## **Development Facilitation Team (DHO) – Review Comments**

**Project No: PR-2022-006674**

### **Application For: SD-2024-00015-Amendment to Preliminary/Final Plat (DHO)**

- A Minor Preliminary/Final Plat adjusting the boundary between two existing lots (Lot 16 and Lot 17 of the Land of Raymond Ortiz), creating two new lots (Lots 16-A at 6,776 square feet in size and 17-A at 5,554 square feet in size) was approved by the DHO on January 10, 2024 per PR-2022-006674 / SD-2023-00197. After the DHO approval, the agent for the application (Cartesian Surveys, Inc.) confirmed that a quitclaim deed (5/21/1982, Bk. 163-A, Pg. 195, Doc. No. 8226991) was discovered that incorporated an existing 14-foot private roadway and access easement into Lot 16-A. Therefore, the Applicant is requesting a minor amendment of the previously approved Plat to incorporate the 14-foot easement into Lot 16-A.

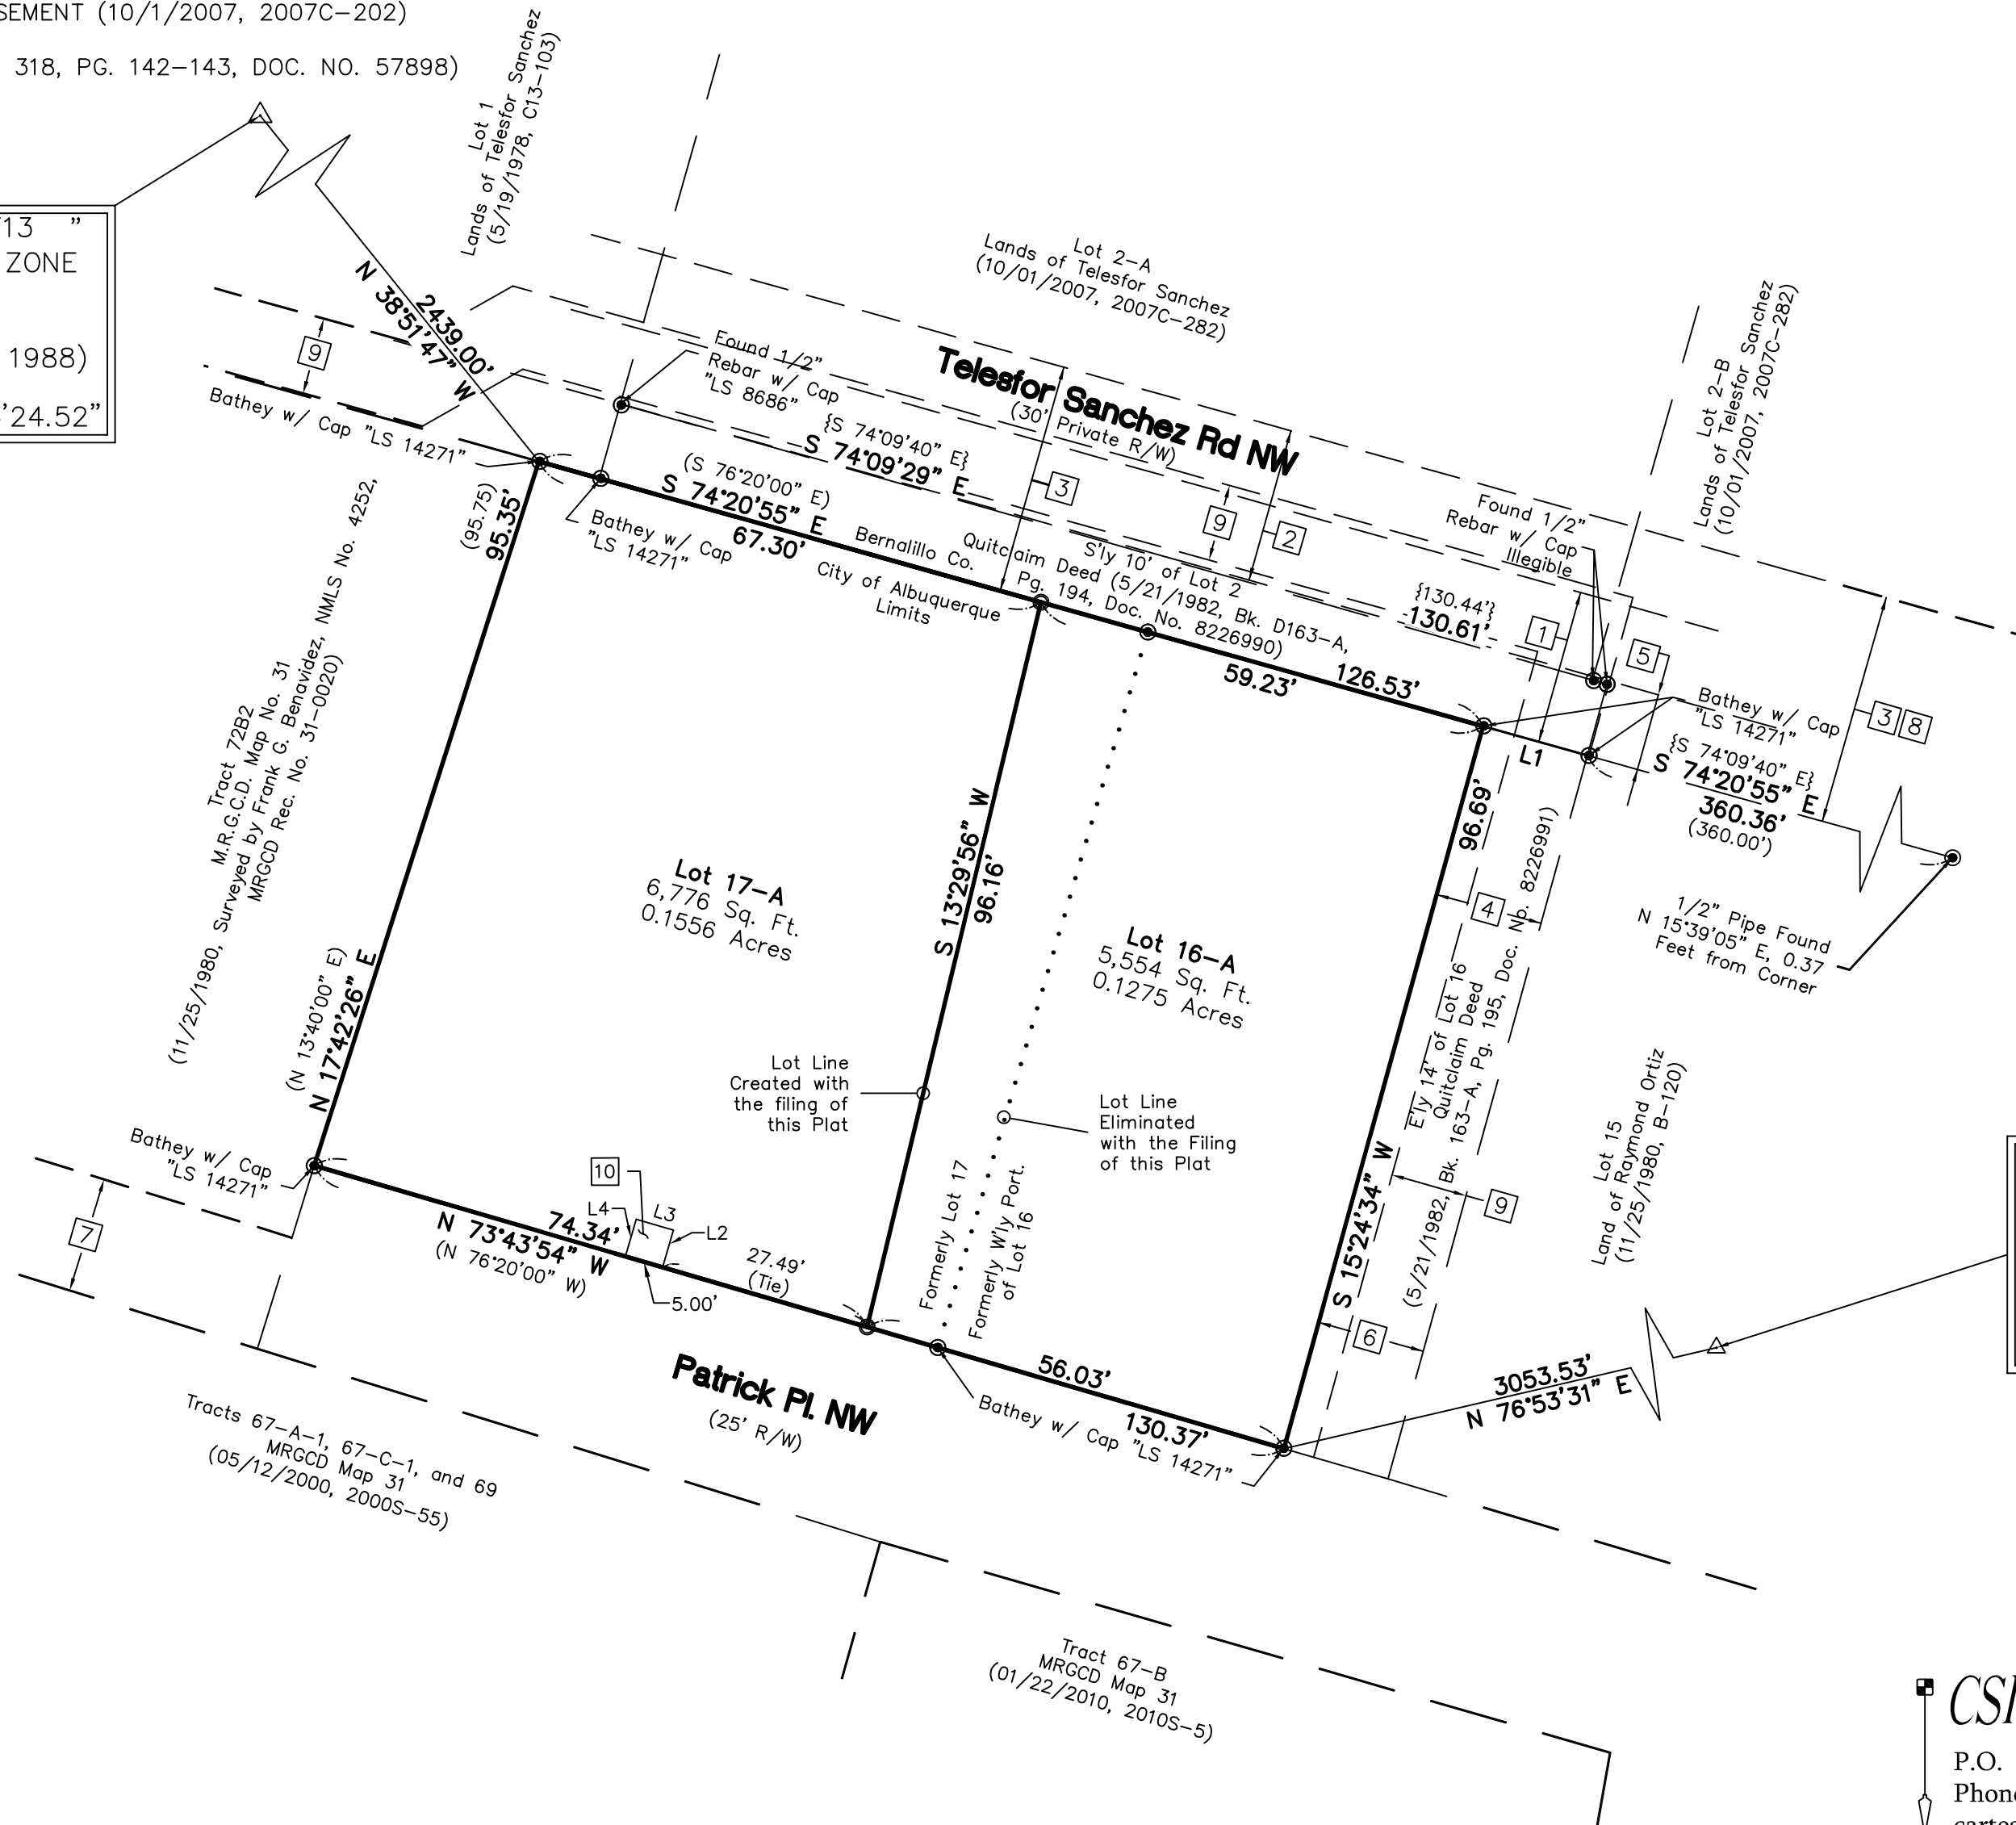
1. Lot 17-A: Lot Width required is 75 ft per Table 5-1-1 for RA-zone.
  - Lot 17-A Deviation of 4.2 feet proposed for width of Lot 17-A is recommended for approval.
2. Lot 16-A: Lot Width required is 75 ft per Table 5-1-1 for RA-zone. This lot appears to be legally non-conforming as to size, with an existing structure that also appears to be legally non-conforming. This would qualify for exceptions allowed under IDO 6-8(E), Non-Conforming Lots, and appears to meet the following requirement:

3. Lot 17-A Deviation: Request deviation of 0.3 feet of the required 20 feet for the Front Setback of Lot 17-A: recommended for approval.
4. Lot 16-A: Deviation. Requested deviation of 0.9 feet for the West side setback of Lot 16-A. This is not required, as it is covered by Variance VA-2023-00284, allowing a reduction of 1 foot to the 10 ft Side Yard Setback of Lot 16. Deviation note should be removed and replaced with the applicable Variance note.

5. Lot 16-A East side yard setback is deficient, showing 8.4 ft of a required 10 ft setback. However, as this structure appears to be an existing nonconforming structure, the existing non-conforming side setback is allowed to continue under IDO 6-8(D) Nonconforming structures, with the following condition outlined as per IDO 6-8(D)(4), regarding future addition or enlargement:

- The AGIS office must approve the DXF file and proof of approval must be provided prior to final sign-off of the Plat.
- The application number needs to be corrected from SD-2023-00197 to SD-2024-00015.
